KITTTITAS COUNTY

DEPARTMENT OF PUBLIC WORKS

January 29, 2021

Below is additional information requested from your January 26, 2021 email related to the comments provided January 26, 2021 for grading permit GP-20-00020 and TC-20-00001, Nunnally Holdings. Your request for additional information is followed by the original comment and a follow up response.

1 SITE PLAN
1" = 150'

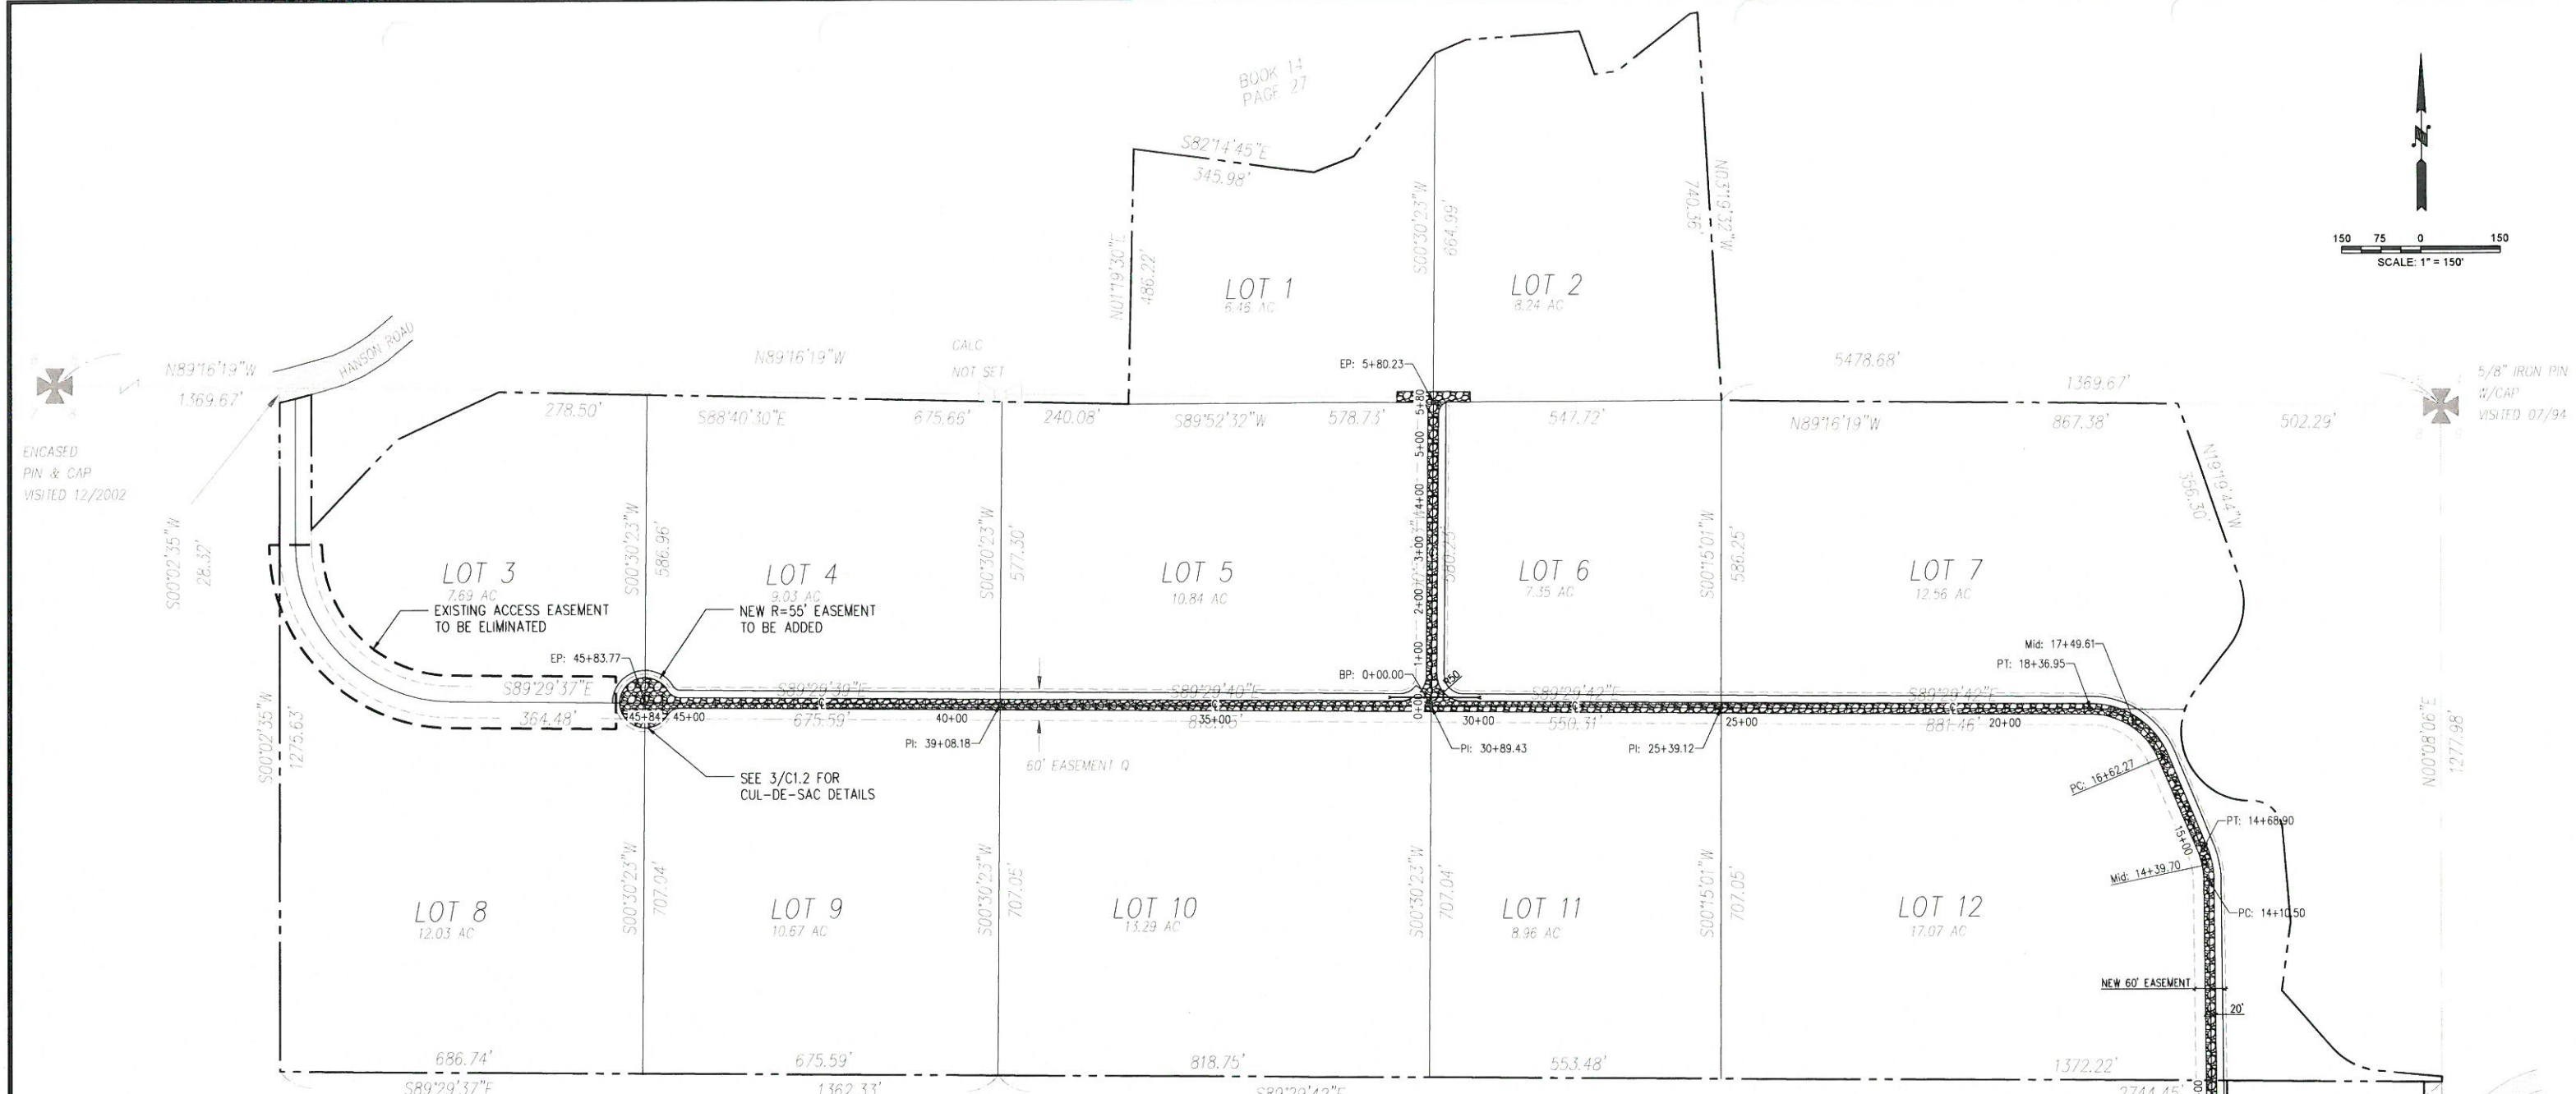
Comment #3: Original administrative segregation included 12 lots. Parcel 748433 should be shown as having access to proposed private roadway.

Response: Access from the original administrative segregation is now shown to utilize Strande Road across parcel 748433 which was not part of the original segregation. Please include a note identifying that Parcel 748433 will access the proposed private roadway. Kittitas County Code 12.05.030(F) indicates access is to be from internal network. Parcel 748433 is the lot which has frontage on County Road and to the internal network. Access to the private road network, rather than directly to Strande Road, will meet KCC and reduce the number of access points onto Strande Road.

4 PROPOSED ROAD SECTION
1" = 5'

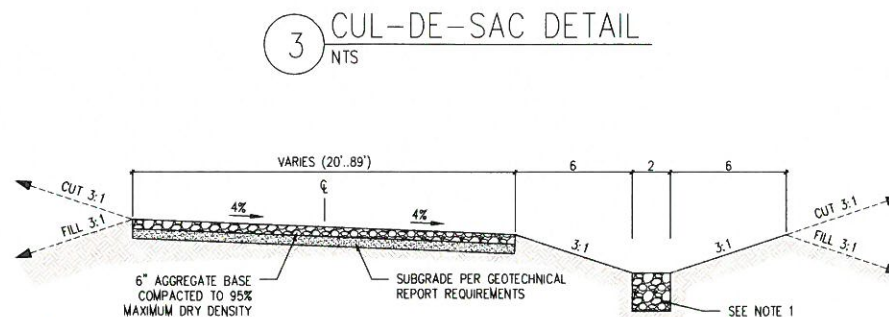
Comment 18: Provide details of proposed gravel road shown on sheet C1.8. Also, provide easement width. Please clarify lot line locations.

Response: It is unclear from the plan sheets if detail 4 from sheet C1.9 will be used for all gravel roads, or only the primary route. The 60 ft easement is also not clear on the plan set. Suggest identifying on each sheet the road detail to be used and the easement. With a plat the easement would be recorded on the face of the plat, as this project appears to not

be updating a plat, please provide information on how the easement will be recorded or conveyed.
